Rezoning Transportation Analysis

Petition Number: 2025-031

From: Jake Carpenter, PE

Date	Description
04-23-25	First Review (TM)
05-21-25	Second Review (TM)
10-23-25	Third Review (TM)

RZ-1.0

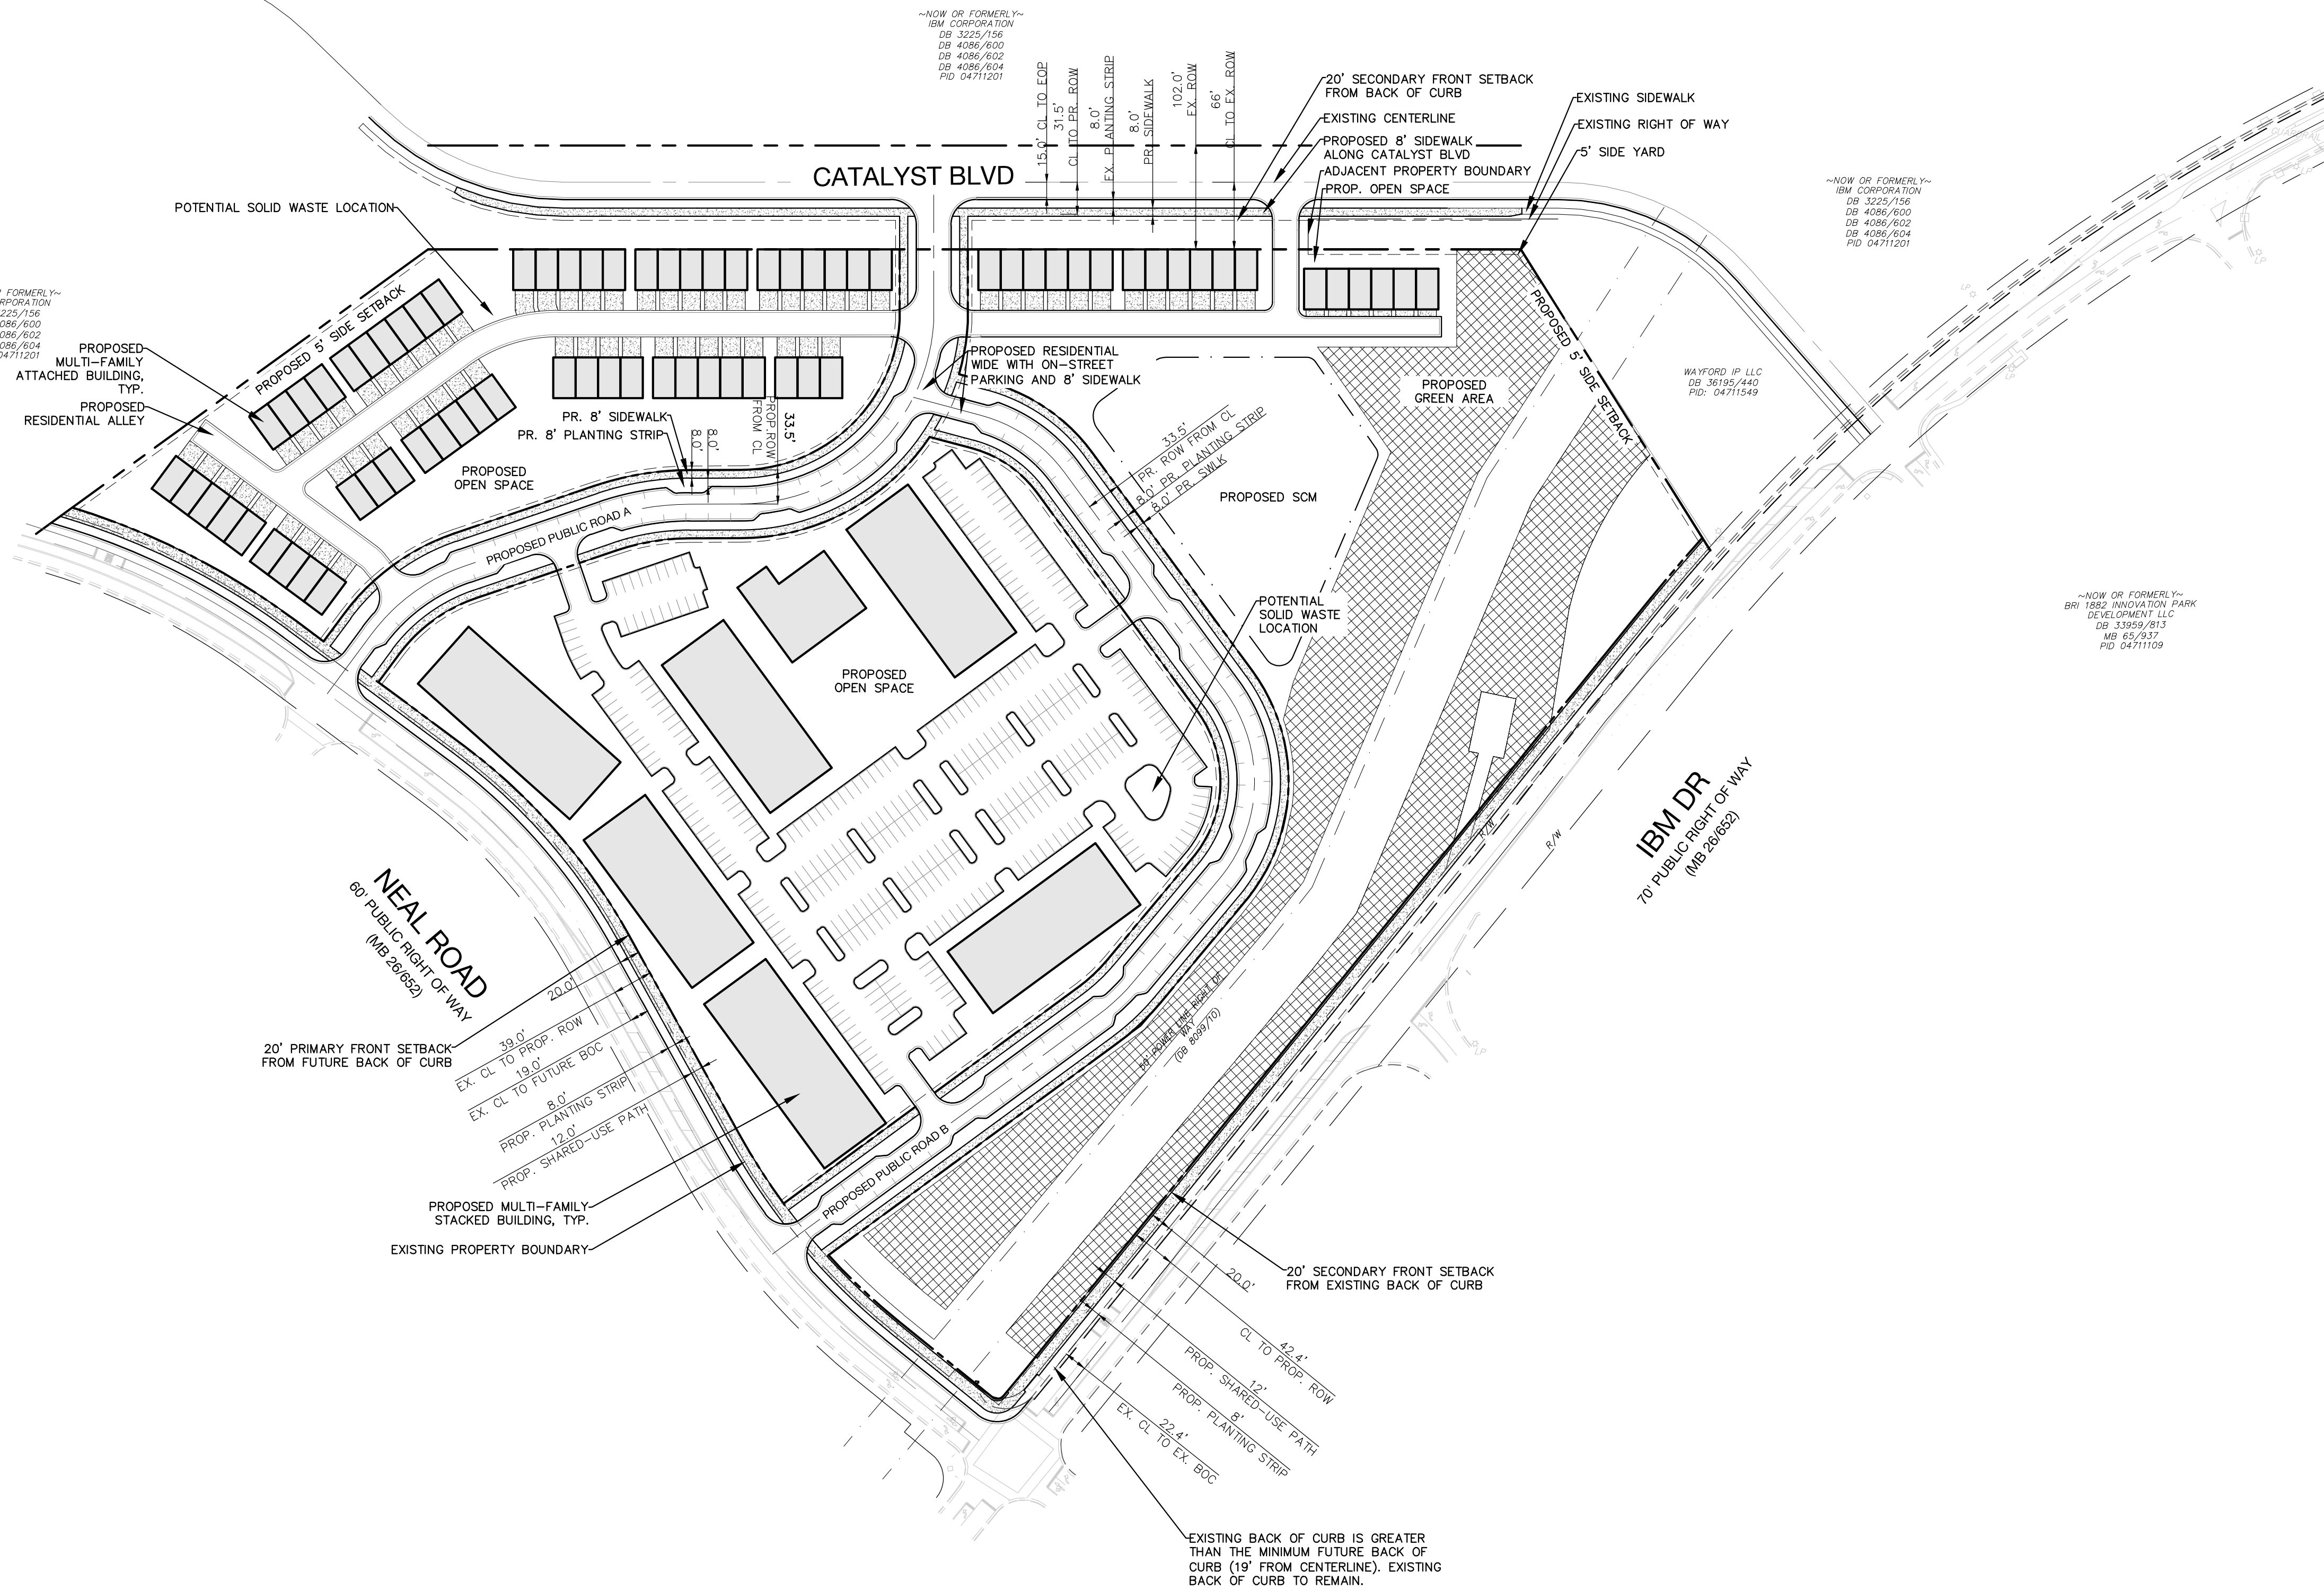
- c. **Catalyst Drive:** Location of future curb and gutter is to follow CLDSM U-03.

Outstanding Comment 4.23.2025: Label and dimension the curb and gutter from the centerline for each road on the site plan.

11. **New CDOT REQUEST 10-23-25:** Add conditional note to provide a minimum of 50' feet of ROW from the centerline of IBM Drive to accommodate the future right turn lane. Some of the ROW can be placed in an SUE. This ROW will allow for a right turn lane to be constructed at the signal which will drastically increase the functionality of the intersection.
